Dinuka McKenzie - We, the residents of Links Estate Casula, Demand Noise Barrier Walls !

Re: Noise Walls along the M5 Corridor! Specifically The Georges River Bridge/Overpass.

Hello. No Noise Walls over the Georges River Bridge. The Links Estate is the only bridge M5/M7/M4

Figure 8.7 Location of existing and proposed new or augmented noise walls

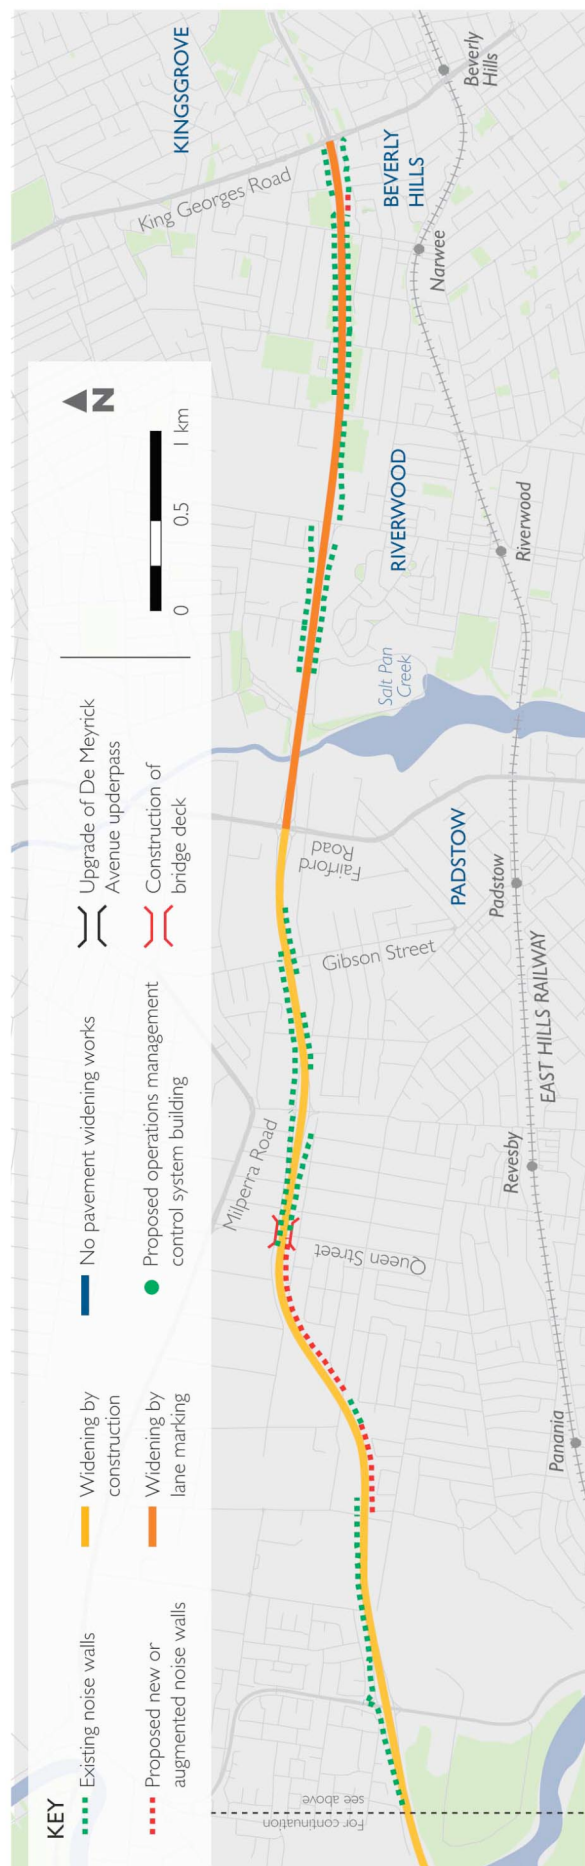
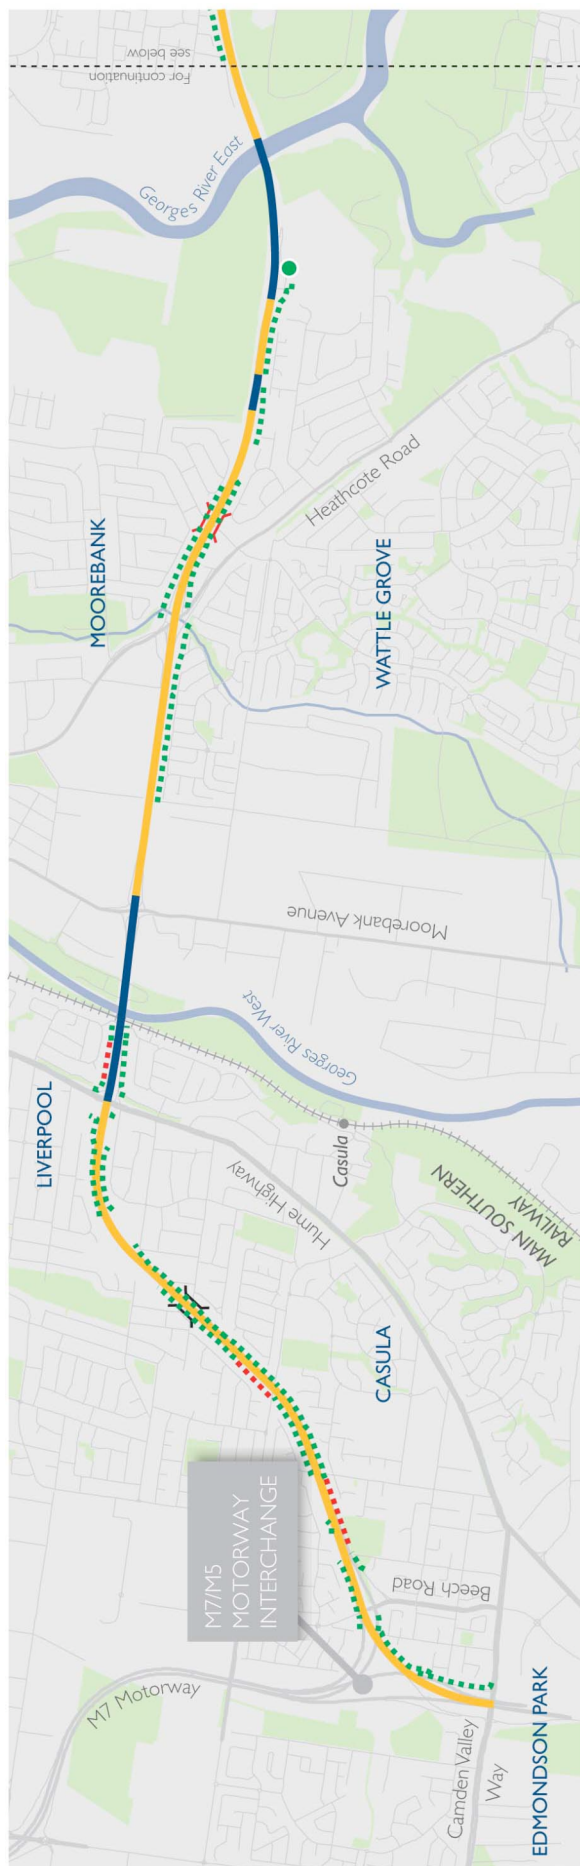
Frankly I, as a resident of Casula's 'Links Estate', find it appalling that the State Government decision to NOT erect Noise barriers along our section of the bridge has been made under the guise of 'not enough complaints!' ~(surely this must be a joke?)~

So as far as noise reduction barriers go, we should have had them installed when the bridge was built..or at the very least when ALL other noise barriers were in the process of being erected!!!

We have the right to demand equally, the noise protection you have already provided to every other section of this Motorway!!! Why are we the sole community being denied?? If it is a matter of money, you should have 'planned' for this years ago!

We are the only bridge on the M5/M7/M4 with no noise walls on the Georges River Bridge. How can you rate Parks, Golf Courses, Factories. before people who have to live, listening to the noise and taking in the air pollution 24-7 and it is going to get worse as the road has to be made wider.

I am writing to you to complain that my area "The Links Estate" is not getting noise barriers on the George's river bridge as part of the project to widen the M5. In fact i am disgusted that the planning department of NSW has agreed to put noise barriers on all other parts of the M5 to protect PARKS, GOLF COURSES, FACTORIES, TREES ETC but has omitted its obligation to people who live in the links estate! Are the people of the links estate not important? We already suffer from terrible noise levels as a result of the M5- these noise levels are deemed unsafe and very dangerous by the World Health Organisation and now with the widening of the M5 the noise is going to increase and have a detrimental impact on health and everyday life in this community.

Please help us! We need noise barriers, our quality of life depends on this decision- WE NEED NOISE BARRIERS to live a normal life. We cannot be the only area left of without noise barriers!
